Re: SSD 7931 Metz Solar Project – Final Layout

Accordingly, please refer to attached updated proposed final layout of the development attached at Appendix A (document ref: *METZSF-CIV-DWG-101 - Site Equipment Layout Rev2*).

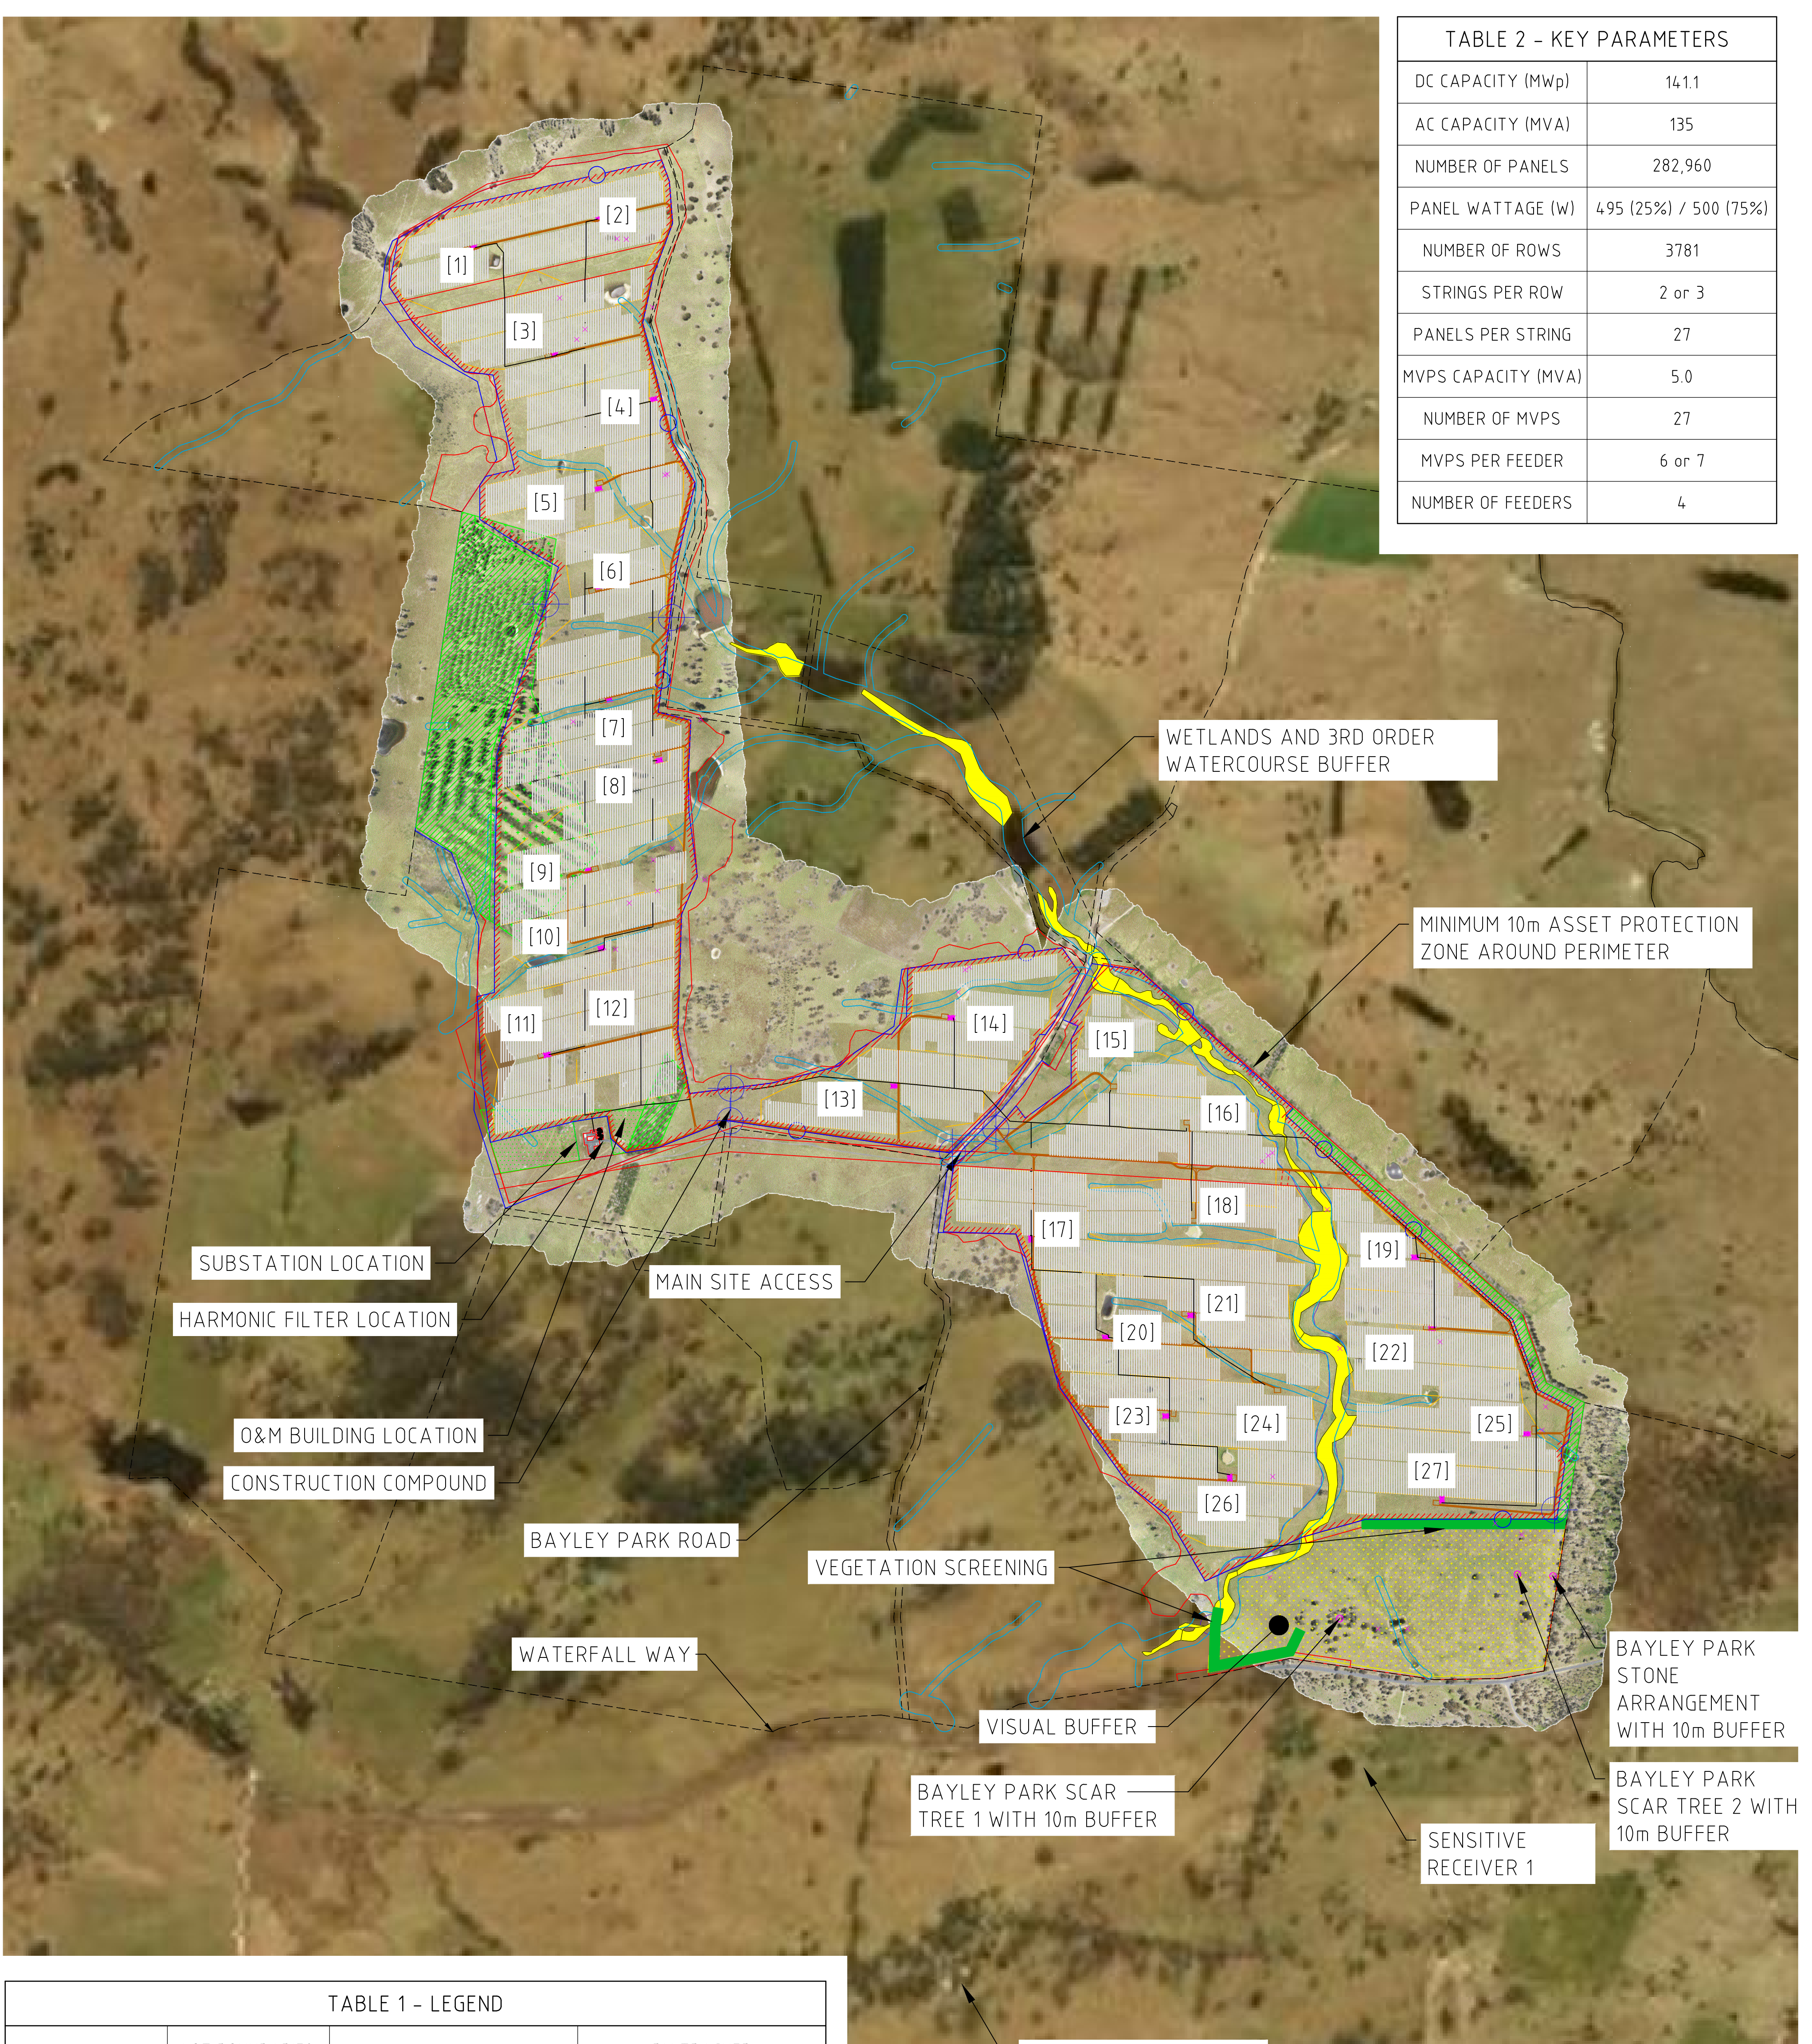
We would like to point to a change in the Final layout. The Asset Protection Zone has been reduced to minimum 10m from a previous 15m. To clarify, a 15m Asset Protection Zone will be maintained all round the site and will only be reduced to 10m in a 185m section on the north-western corner of the development (shown in a revision cloud in the document ref: *METZSF-CIV-DWG-101 - Site Equipment Layout Rev2 – Sketch* and pasted here below.)

In this section, the fence would be moved inwards towards the Solar Farm's equipment and away from the property boundary fence. So, from the solar farm equipment outwards, we would have, a 10m Asset Protection Zone, the fence, a 5m wide path and then the boundary fence (existing).

This path comes at the request of the landowner, for farming operations and access over the land. The landowner keeps operational control over land not leased to the solar farm (that envelops the solar farm). In this particular area, the solar farm extends to the limit of his property, cutting access to either side of the farm. A 5m wide path would allow him to continue his operation unencumbered.

This 10-meter Asset Protection Zone would still be in line with the Construction Bushfire Management Plan approved by RFS. (Document ref: 05.05.05.07.09 METZ_BFMP_001B section 4.1.2 ASSET PROTECTION ZONE)
